**HUNTER VALLEY OPERATIONS SOUTH MP 06_0261 MOD 5
REQUEST FOR MORE INFORMATION**

**ENVIRONMENT PROTECTION AUTHORITY – REVIEW OF ENVIRONMENTAL ASSESSMENT
MP 06_0261 MOD 5
HV OPERATIONS PTY LTD**

Figure 6-4: Locations available for contemporaneous cumulative impact assessment

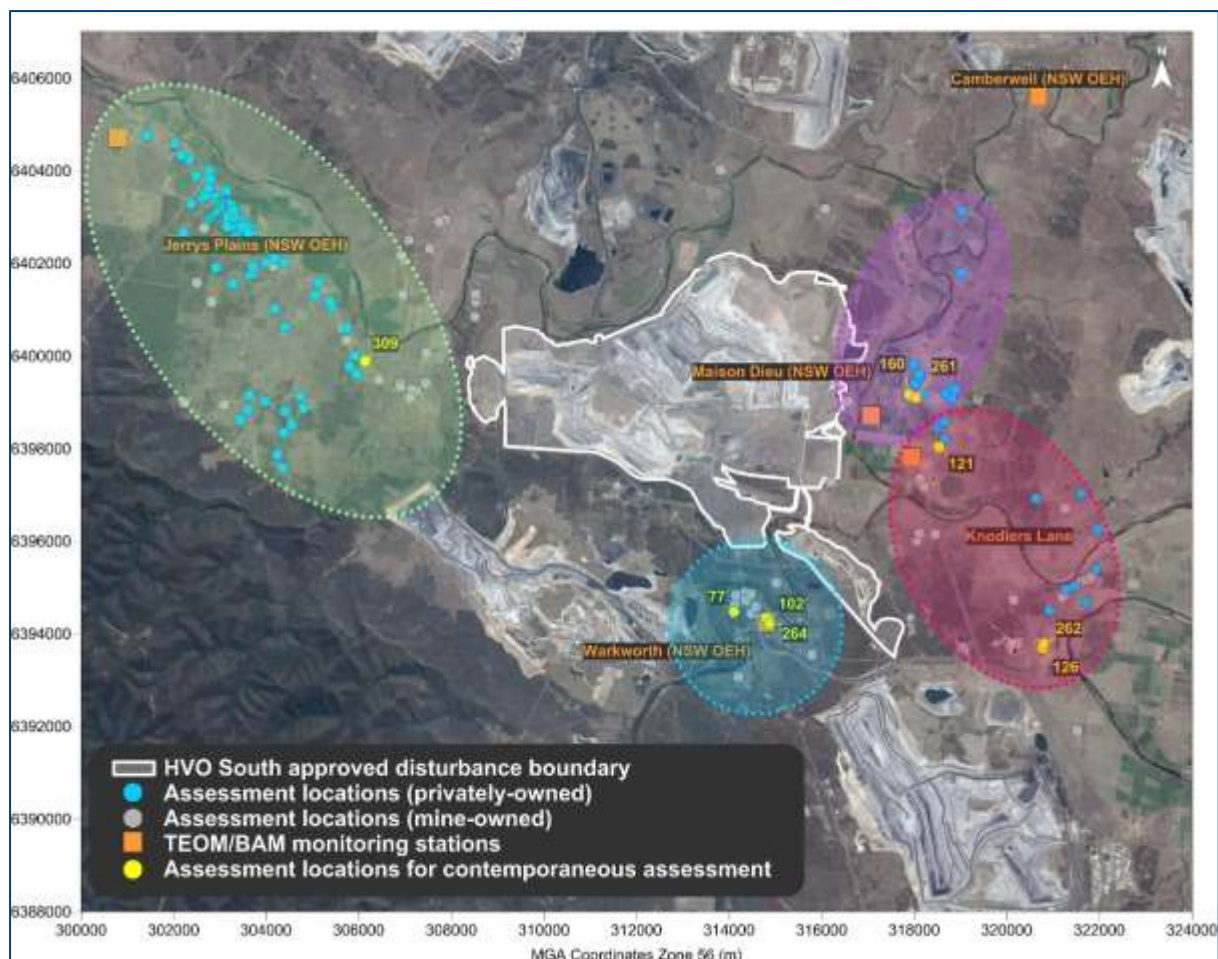
4. Provide a label for receptor 471 in Figure 6-4;
5. Provide cumulative assessment for receptor 471;
6. Identifies all non-mine receptors assessed and experiencing one or more additional exceedances of cumulative impact assessment criteria;

Figure 6-6: Predicted 24-hour average PM<sub>2.5</sub> concentrations for assessment locations 126, 160 and 309 during Stage 3

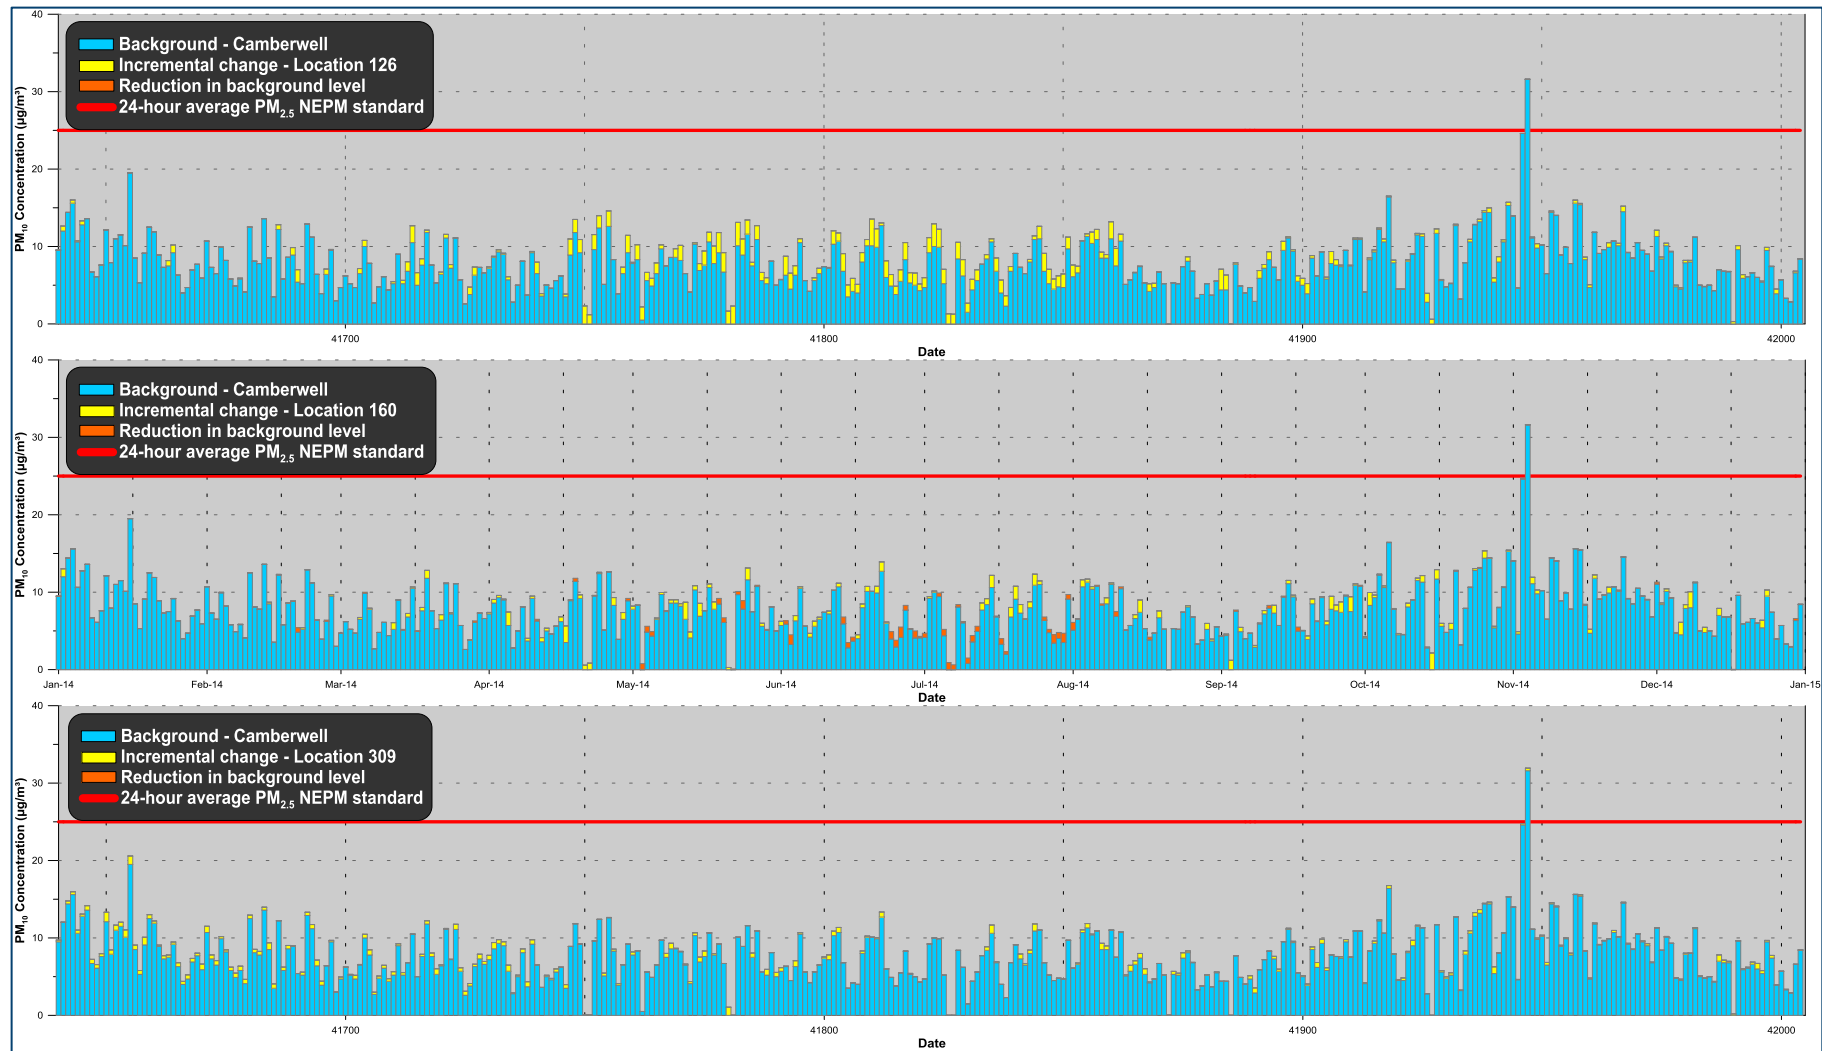
2. Provide an explanation of how current operations were accounted for in the cumulative assessment;
3. Provide an explanation of the reason for background reductions represented by orange bars in Figures 5-5 and 6-6;
